Ref BR/41/13

With regard to the application, I strongly disagree that 6 two bedroom dwellings should be built on this site.

PROPOSED ELEVATIONS ~ PLOTS 4,5 & 6

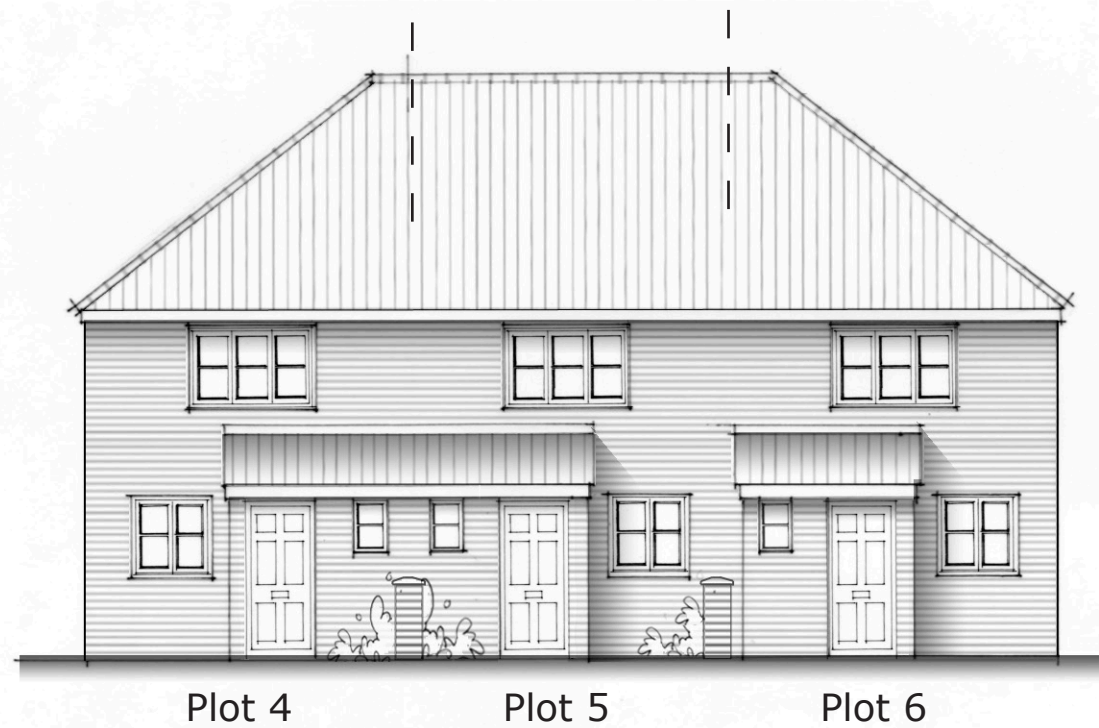
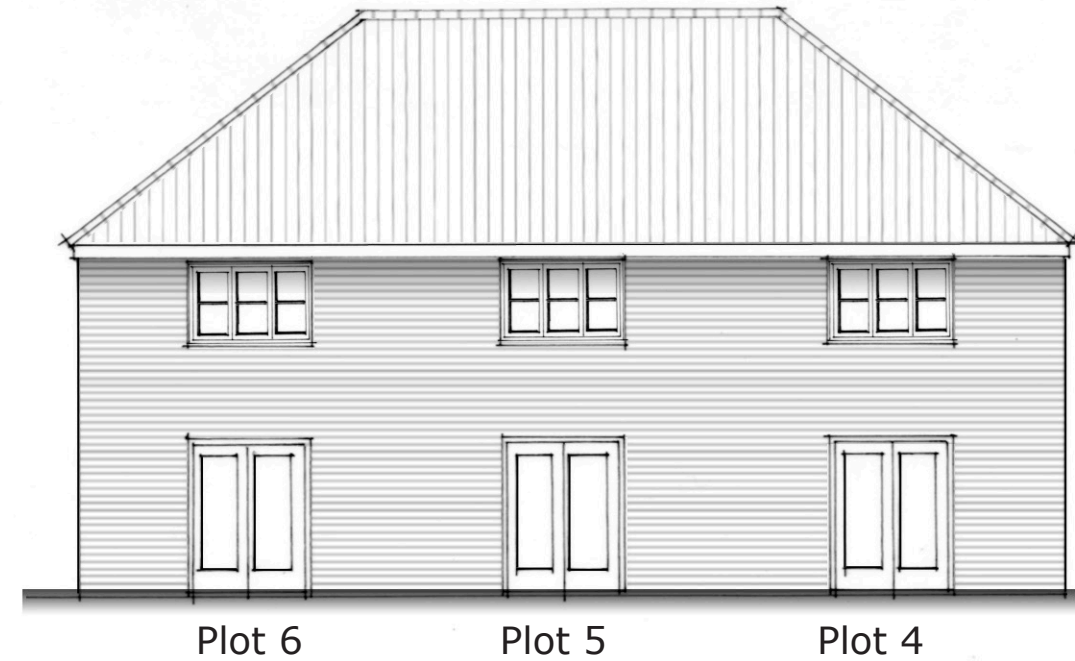
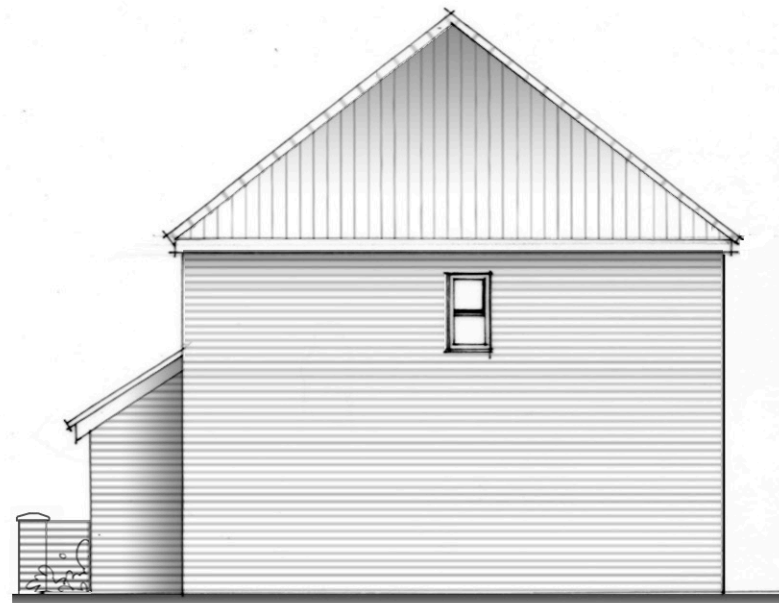
Plans show that my house will now be overlooked; by a two storey building, I will lose my privacy within my home and in my garden I bought this house because it was not overlooked by any other housing.

6no two bedroom houses with 9no parking spaces

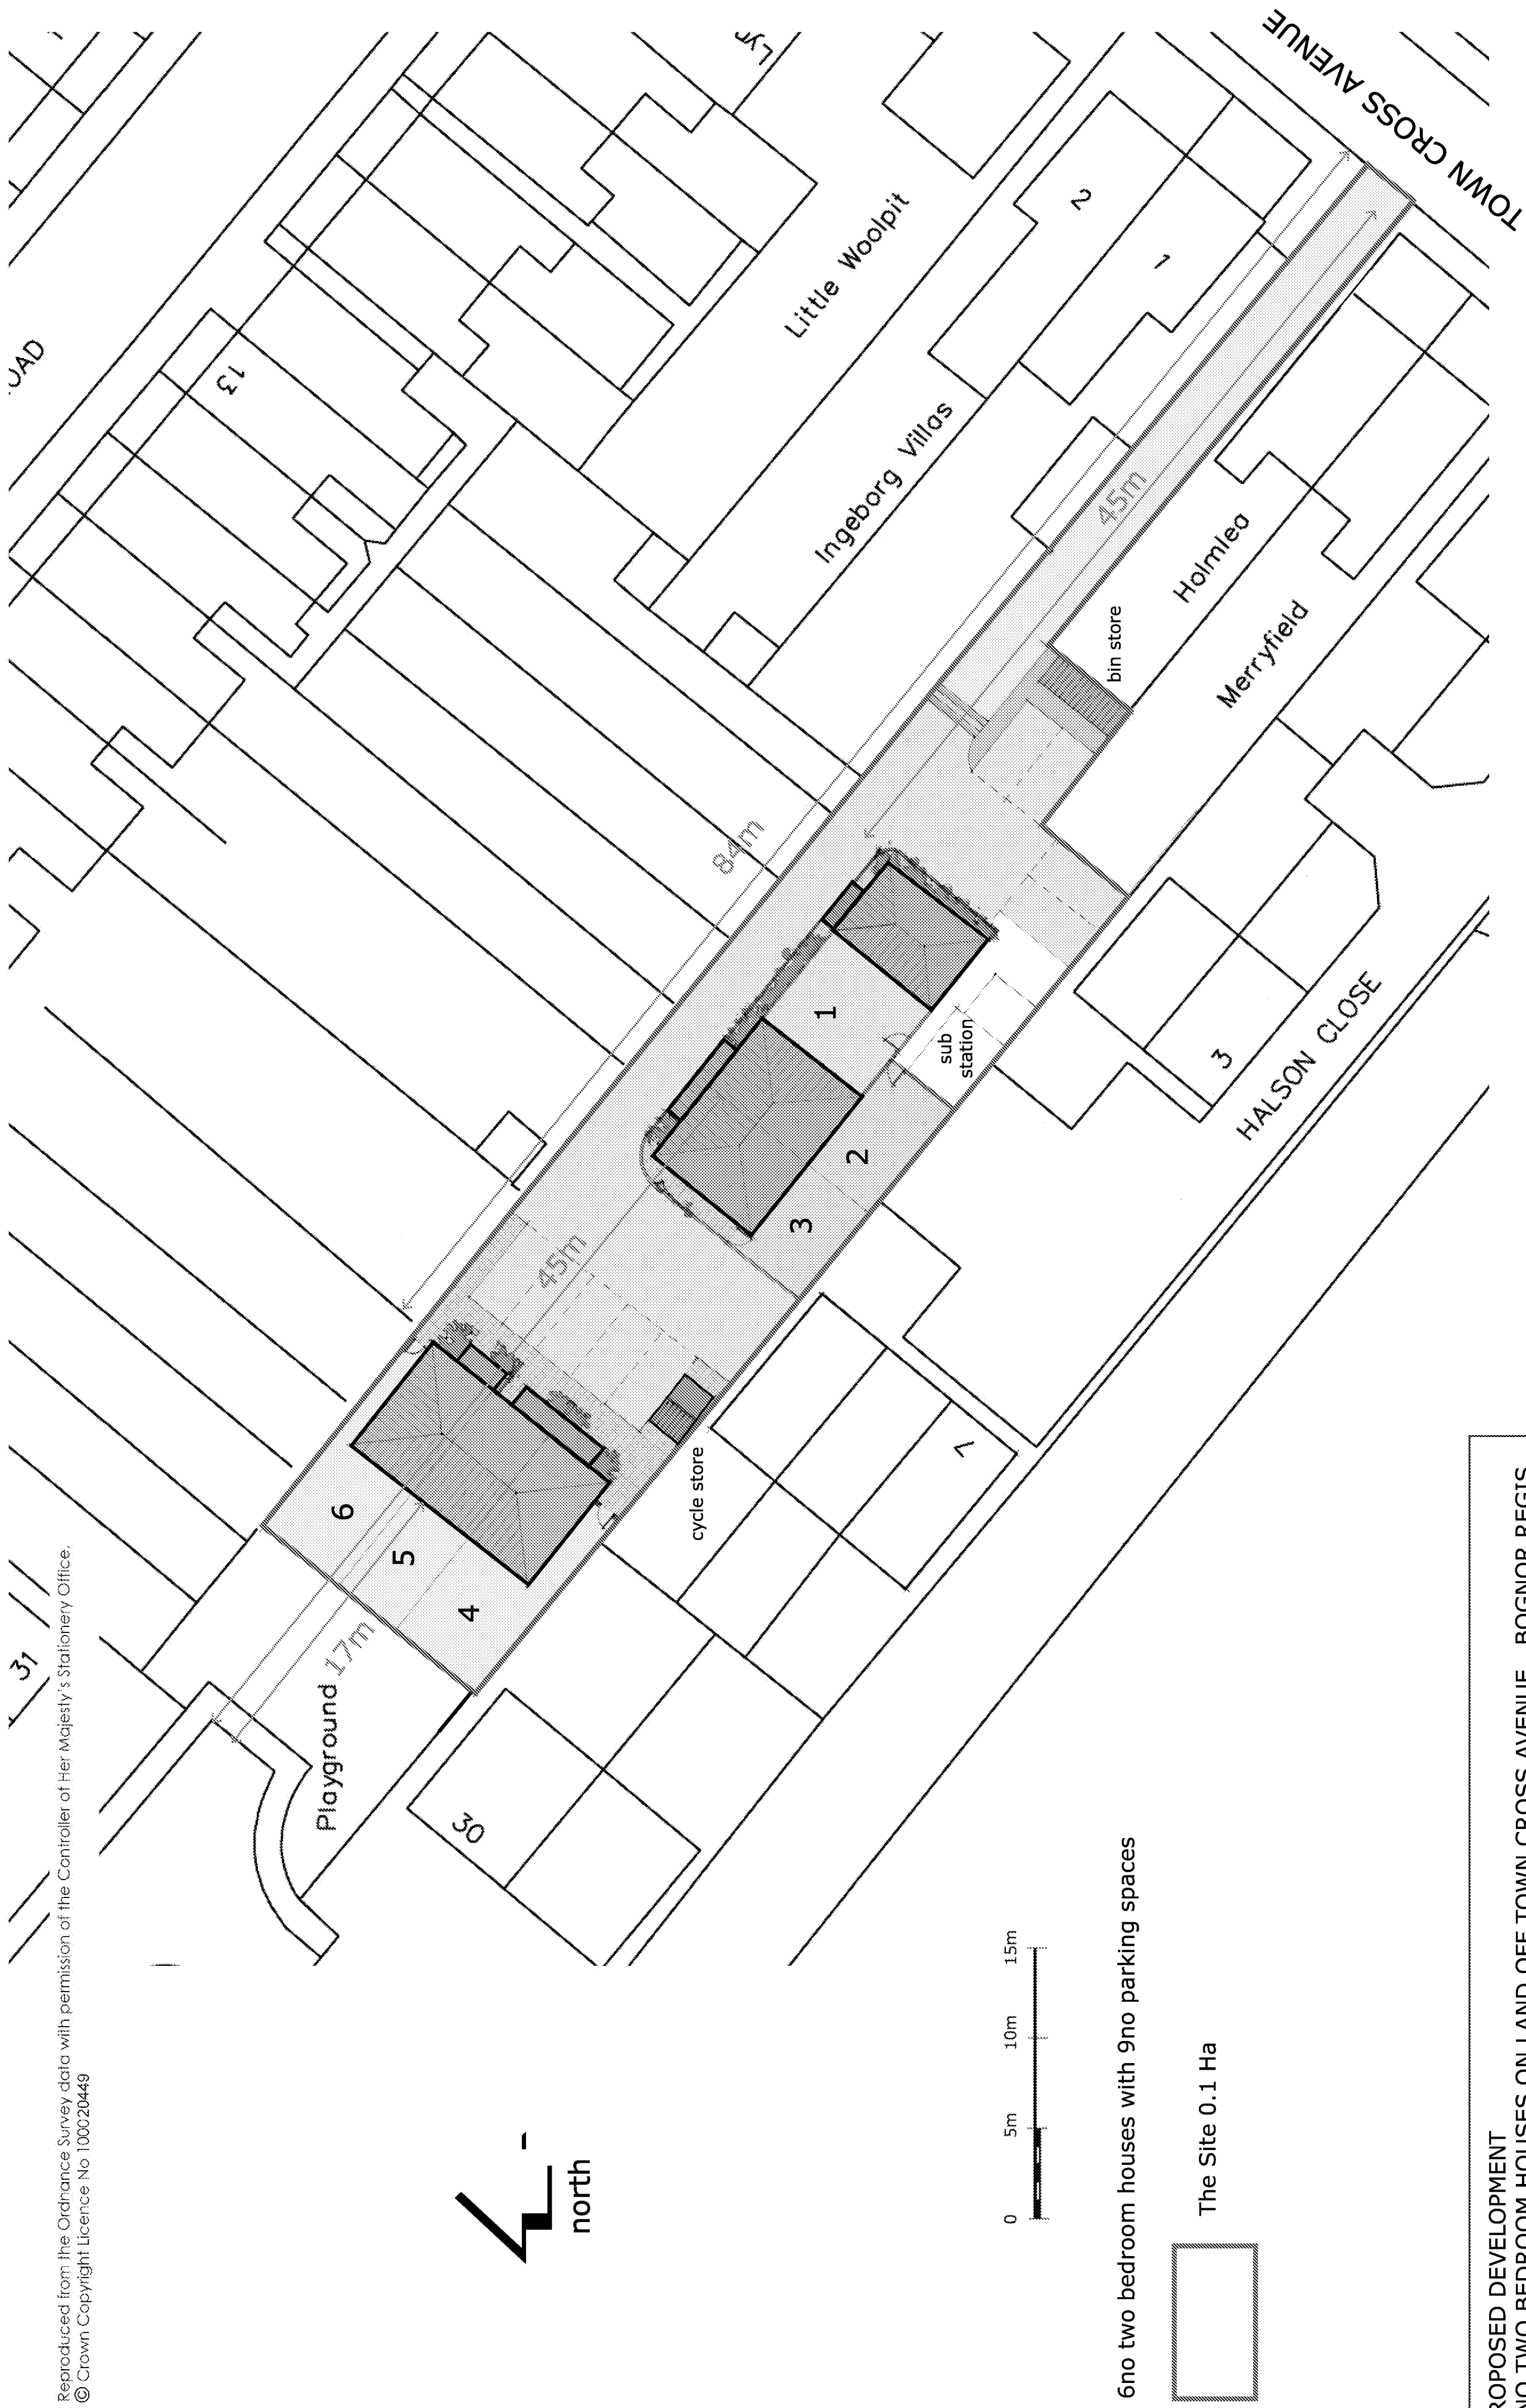
The plans show that refuse bins for the site will be situated at the bottom of my garden, behind my fence, these will be used day and night and will cause me noise disturbance as well as possible odours and make using my garden unpleasant.
